STATE OF NORTH CAROLINA
DEPARTMENT OF TRANSPORTATION

SUBJECT: Buncombe County, Replace Bridge No.134 over Stony Fork Creek; T.I.P.
Number B-4034; Federal Aid Project No. BRSTP-151(10); State Project
8.1845901

From: Beckwith, Loretta A SAW [Loretta.A.Beckwith@usace.army.mil]
Sent: Monday, November 15, 2010 11:32 AM
To: Lusk, Elizabeth L
Cc: Leamer, Jeremy T; Dagnino, Carla S
Subject: RE: B-4034 messages

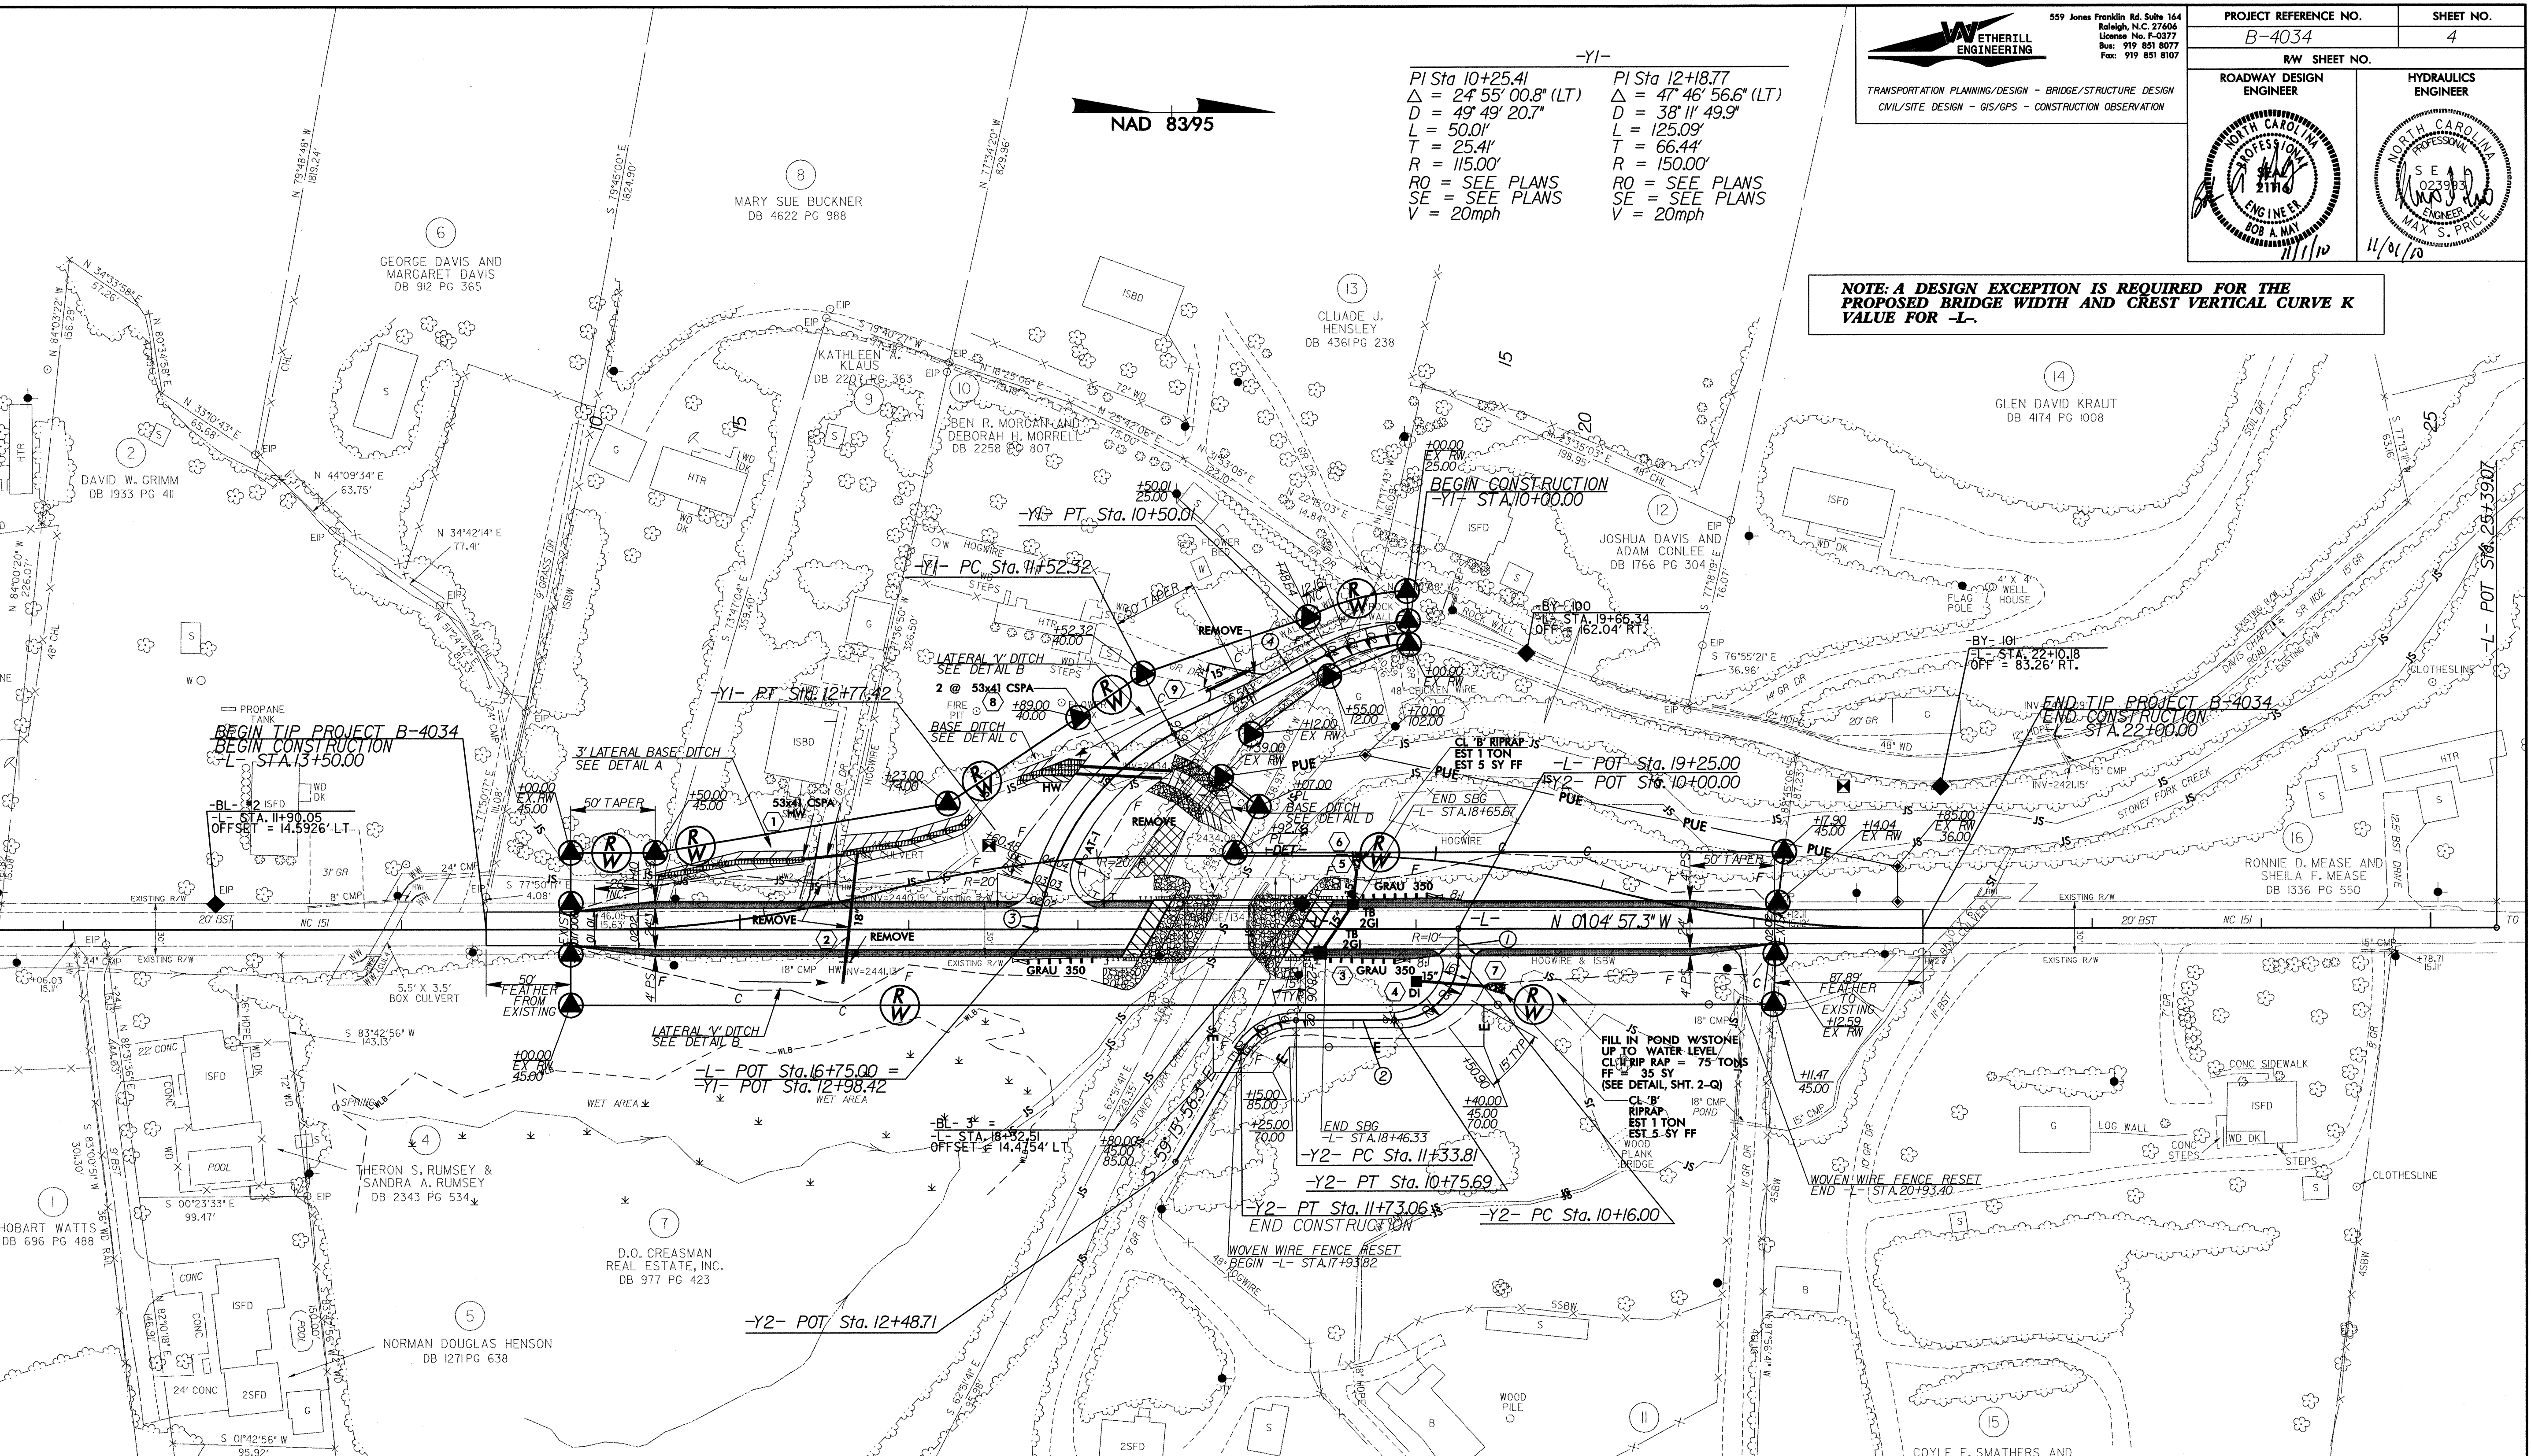
As we discussed last week, in order to comply with a requirement from Land Quality, you will add rip rap (class B stone) to the newly relocated channel (UT to Stony Fork Creek). All rip rap will be flush with the bottom base of the new channel.

Yes, the main crossing has not changed from our application. There will be a spanning structure over Stony Fork Creek. Please note that there is no new fill in Waters of the U.S. and, as Carla noted, the invert of the rip rap will be the base of the new channel, i.e. the rip rap will be "keyed into" the channel, not merely sitting on the bottom.

At the risk of sending you something you've already been sent, I'm attaching the revised plan sheet. I believe the only change was to Detail A at the bottom of the sheet.

After review of the plans (attached to this e-mail) and comments from WRC, we have determined that the addition of 375' of rip rap, if installed so that it is flush with the bottom of the new channel, is reasonable. As such, you are authorized to place the rip rap along 375' of new channel. No additional mitigation is required.

In addition to ensuring that the rip rap is flush with the bottom of the new channel, the project must be conducted in compliance with all conditions of the original verification letter of October 15, 2009.
